Using an ADA, no slope. Redlines

ADD PCD # PPR2220
to all project documents

American Dog Pros Site Plan

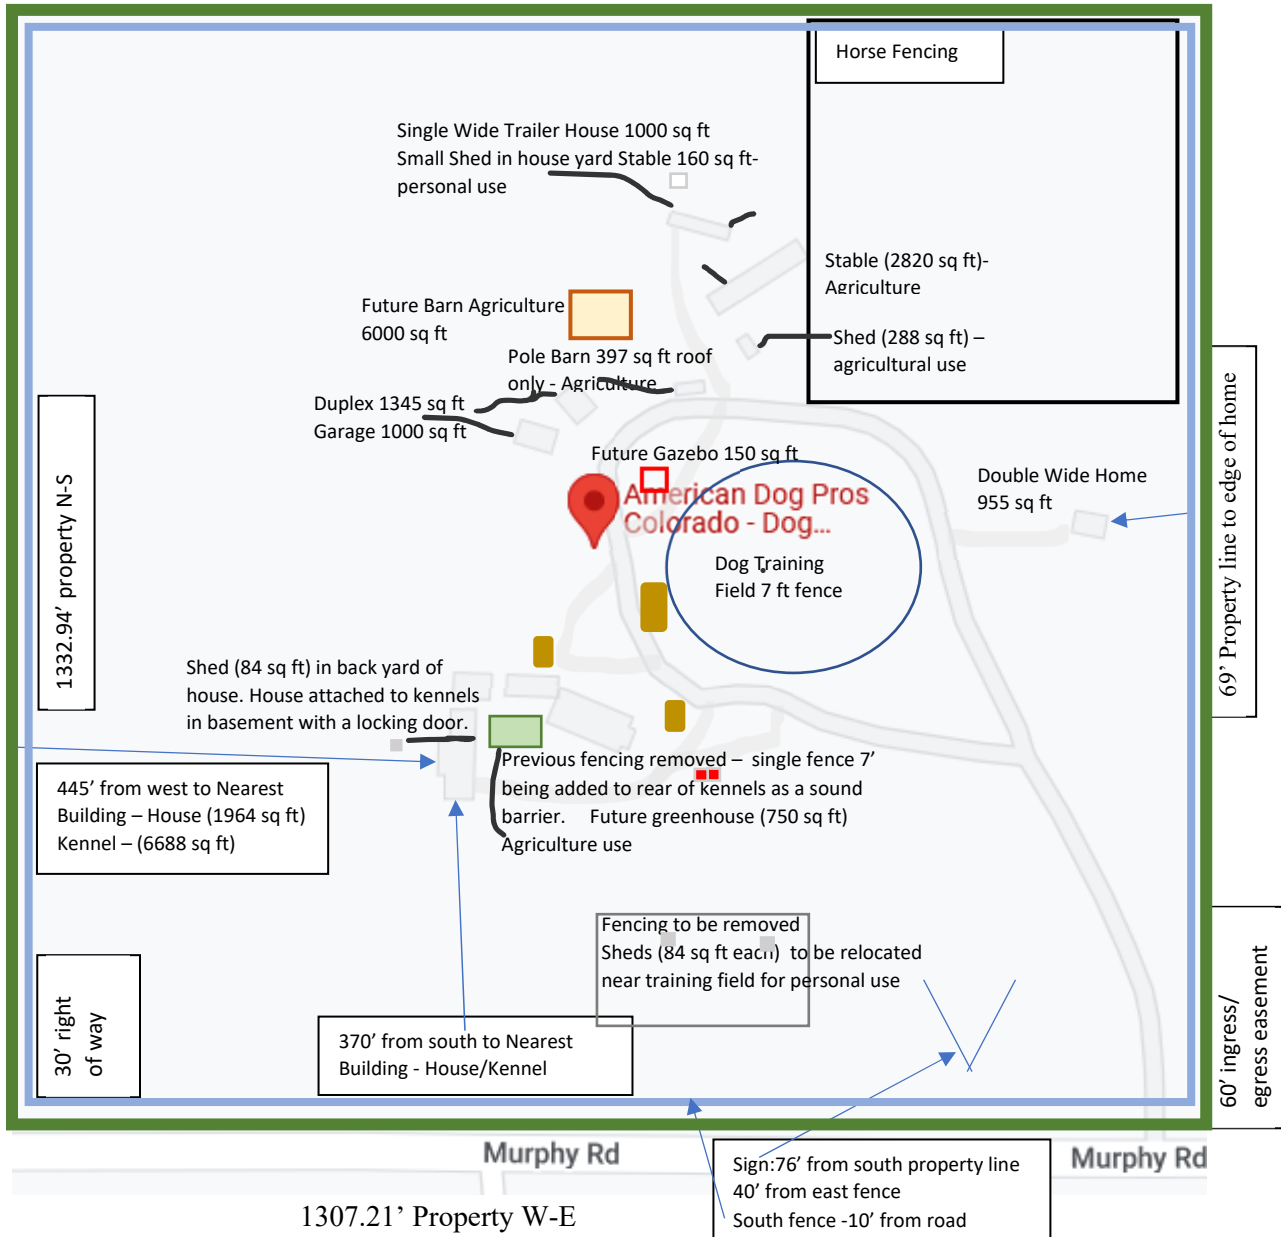
Need to insert ADA compliance comment per 6.1.3 of LDC. Also need to highlight ADA pathways.

Need to insert ADA compliance comment per 6.1.3 of LDC. Also need to highlight ADA pathways.
